Subject: Planning application S6/2009/0995/LB & S6/2009/0994/AD - THE LISTED HANGER Mosquito Way

HCC ref: WH/191/2009

INSTALLATION OF TWO REPLACEMENT LOGO SIGNS

Proposed New External Signage
Building Mounted

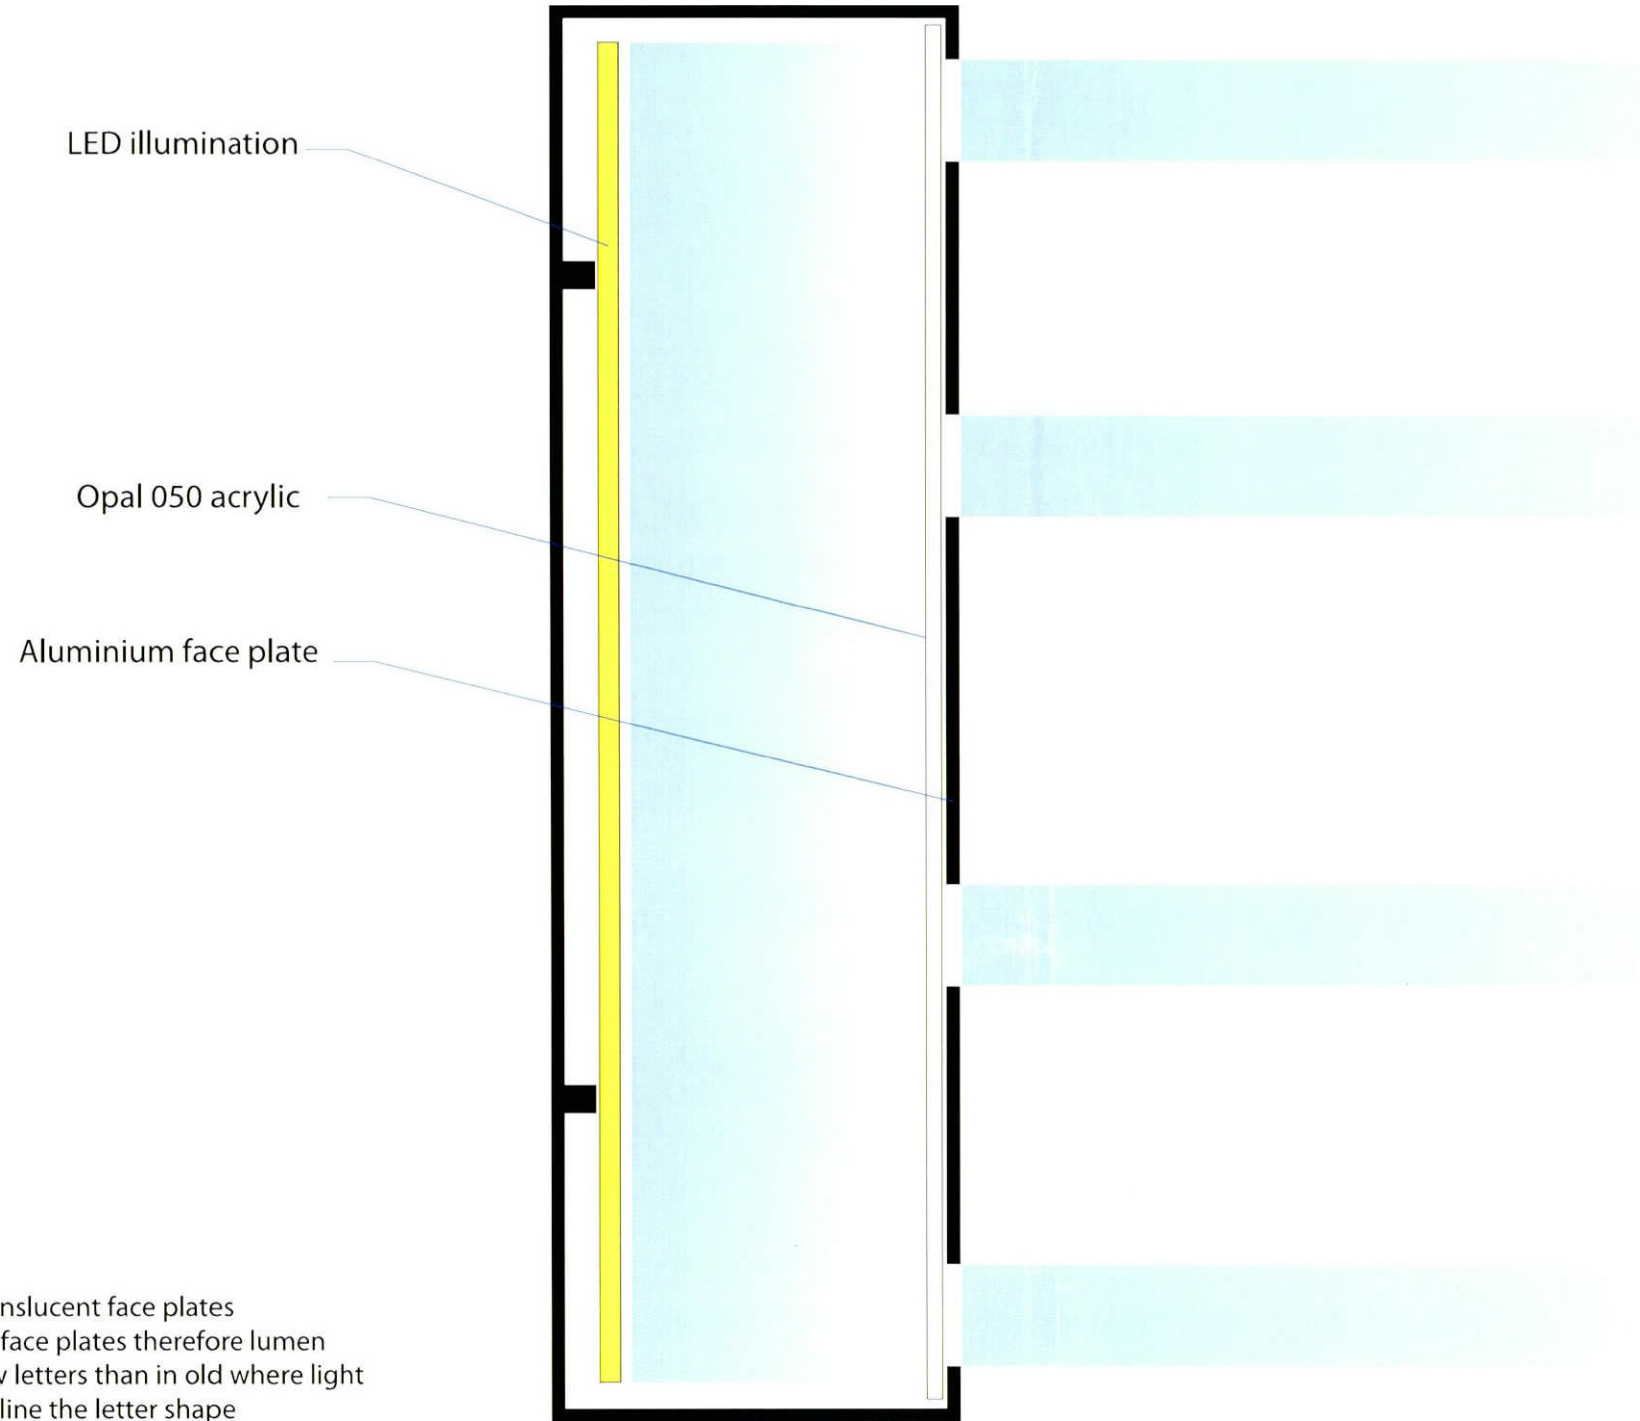
1) The standard of luminance shall comply with the recommendations set out in Chapter 8 of the Institution of Lighting Engineers' Technical Report Number 5 "Brightness of Illuminated Advertisements" (Third Edition 2001).
